Planning and Regulatory: G.Mansfield
Reference: PB2018/05114

**MIXED USE DEVELOPMENT (SSD 8440) 42 HONEYSUCKLE DRIVE,
NEWCASTLE**

I refer to your email of 2 May 2018 advising the applicant Doma Holdings (Honeysuckle) Pty Ltd has submitted further information (Response to Submissions), including amended plans, and inviting Council to comment.

The *Response to Newcastle City Council's Submission* ('the Response'), prepared by KDC, dated April 2018 and other relevant information, as well as the amended plans submitted to the Department on 15 May 2018 have been reviewed by Council officers and the following comments are offered for your consideration:

Scale	1:150	@ A1	1:300 @ A3
Drawn	MDJ	Checked	VG
Project no.	s12109		
Status	DA		
Plot Date	27/09/2017 6:06:15 PM		
Plot File	\\lv-vfp-01\home\JDM\Documents\42HONEYSUCKLEDRIVE_BS_ARCH_DA_JDM.rvt		
Drawing no.	A03.101	Revision	A

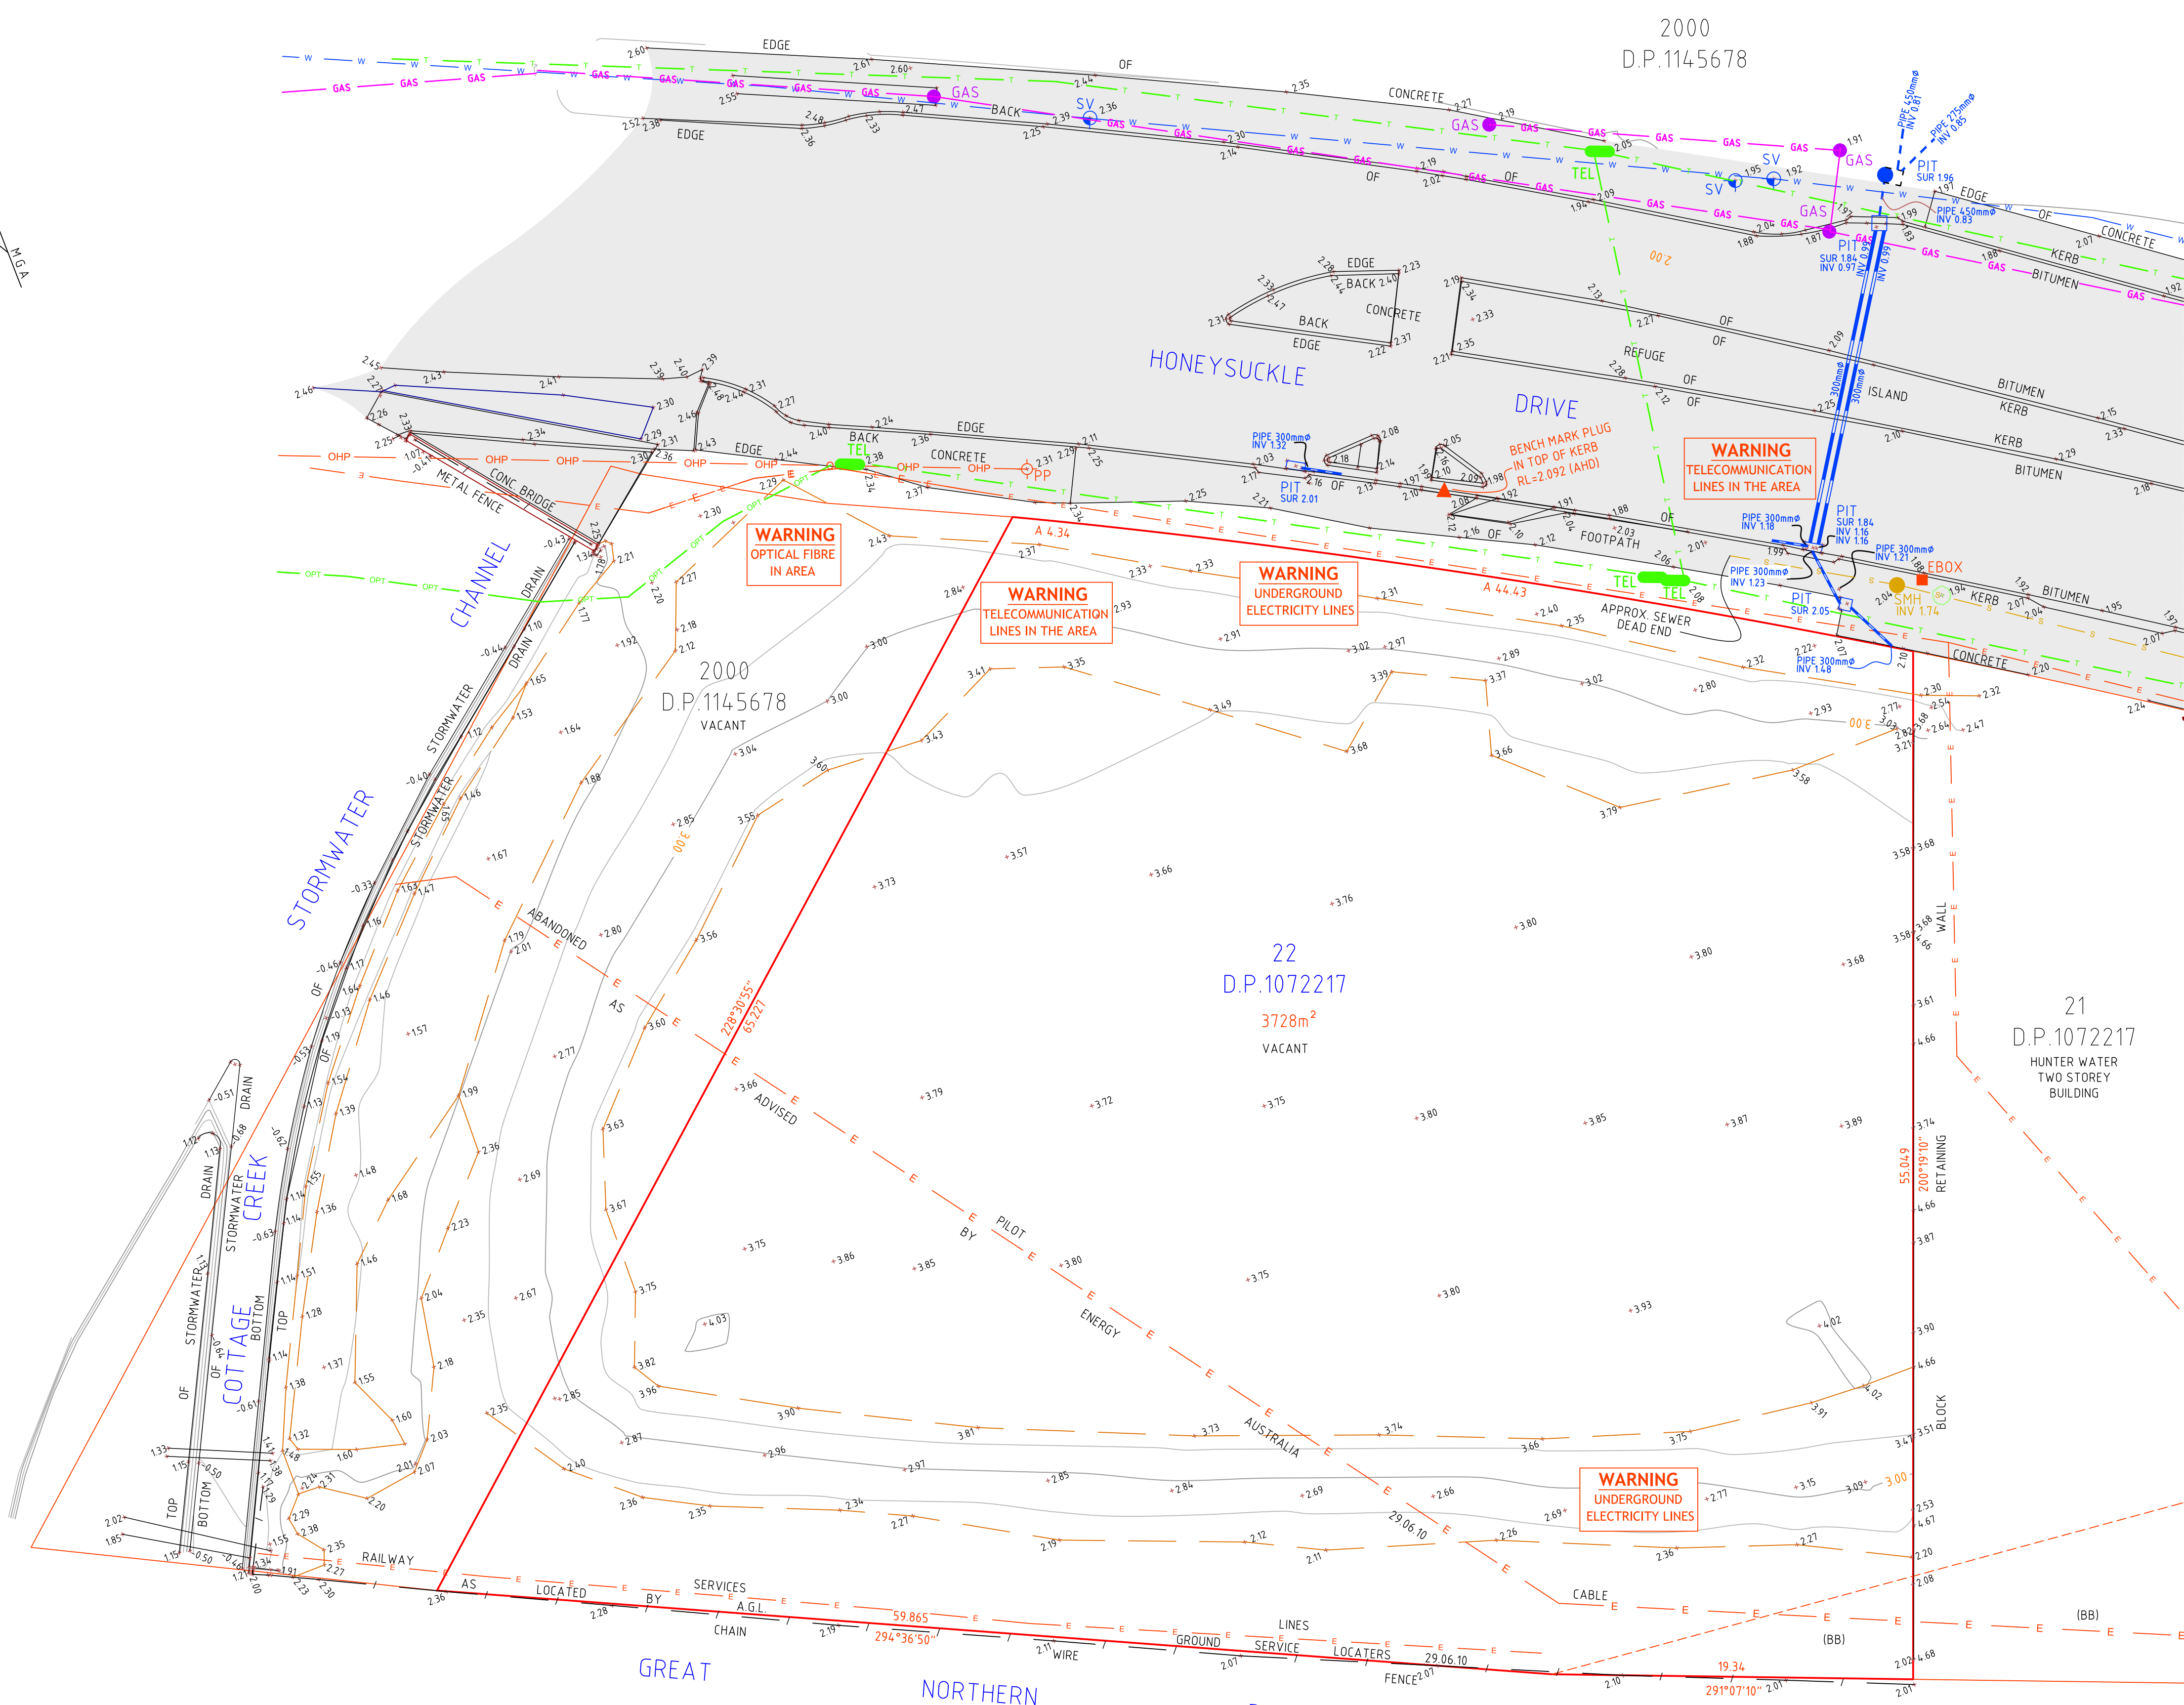
It is noted on the amended plans the vehicle turntable has been deleted and a bin collection area has been provided predominantly on the public footway in Honeysuckle Drive in front of the *transformer landing zone* of the proposed building.

No explanation has been provided in the Response for these amendments or consideration given to the likely impacts. The location of the bin collection area (BCA) on the footway is not supported and the design of the development is to be modified so the BCA is located in the proposed building no greater than 20 metres from the street frontage, or alternatively the residential waste is collected by a private contractor on site and the WMP is amended accordingly.
